**CBL:** 085 S00400      **Permit ID:** 2014-02092

**9/22/2014-AMACHADO/Zoning:**

Rand 17 3rd Street Peaks Island  
Proposed Deck Extension

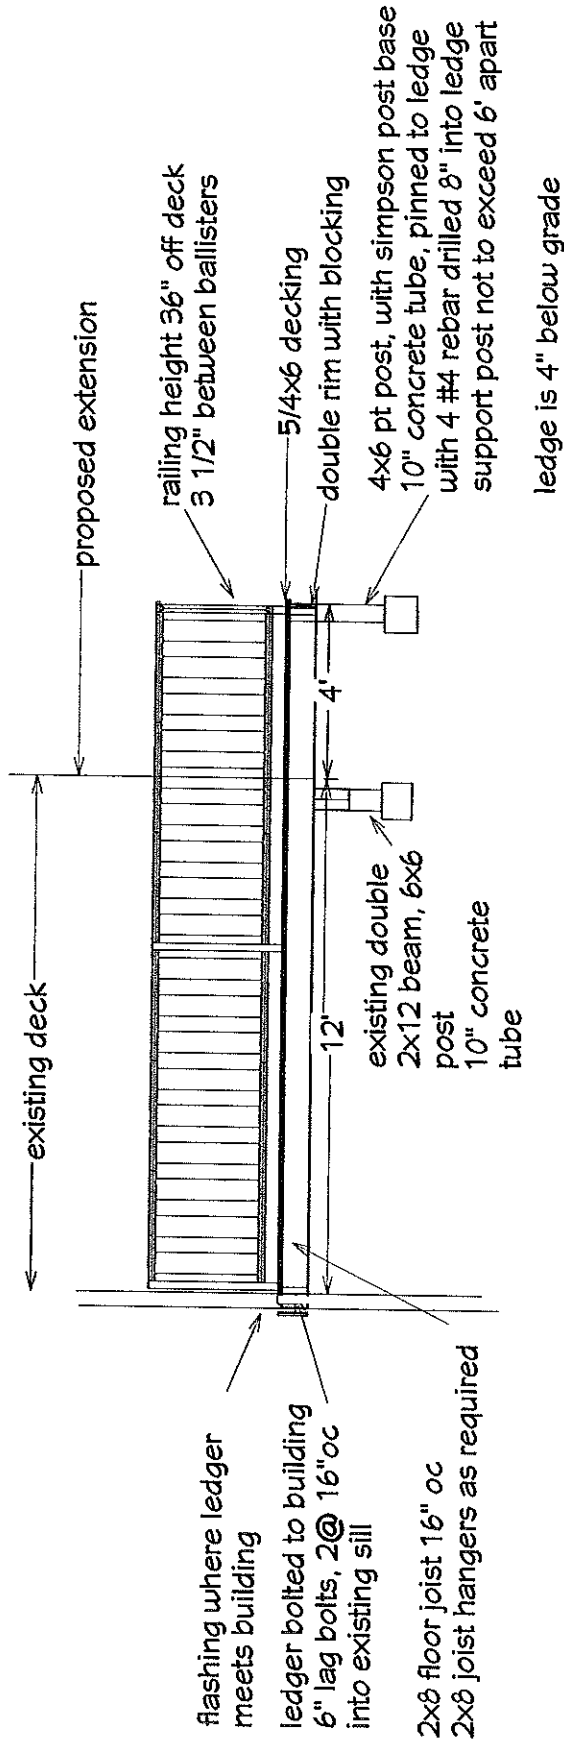
Project description stated an 8' x 10' expansion of the deck but the deck plan showed an expansion on the other side as well. No plot plan was submitted. Spoke to Doreen (intake staff). Asked her to notify the applicant to clear up the project description and get the plot plan.

An error was made in the zoning review for the front yard setback. The part of the deck that extended toward the front should have met the 25' front setback. This was not caught under the zoning review and the deck as approved under this permit is legal.
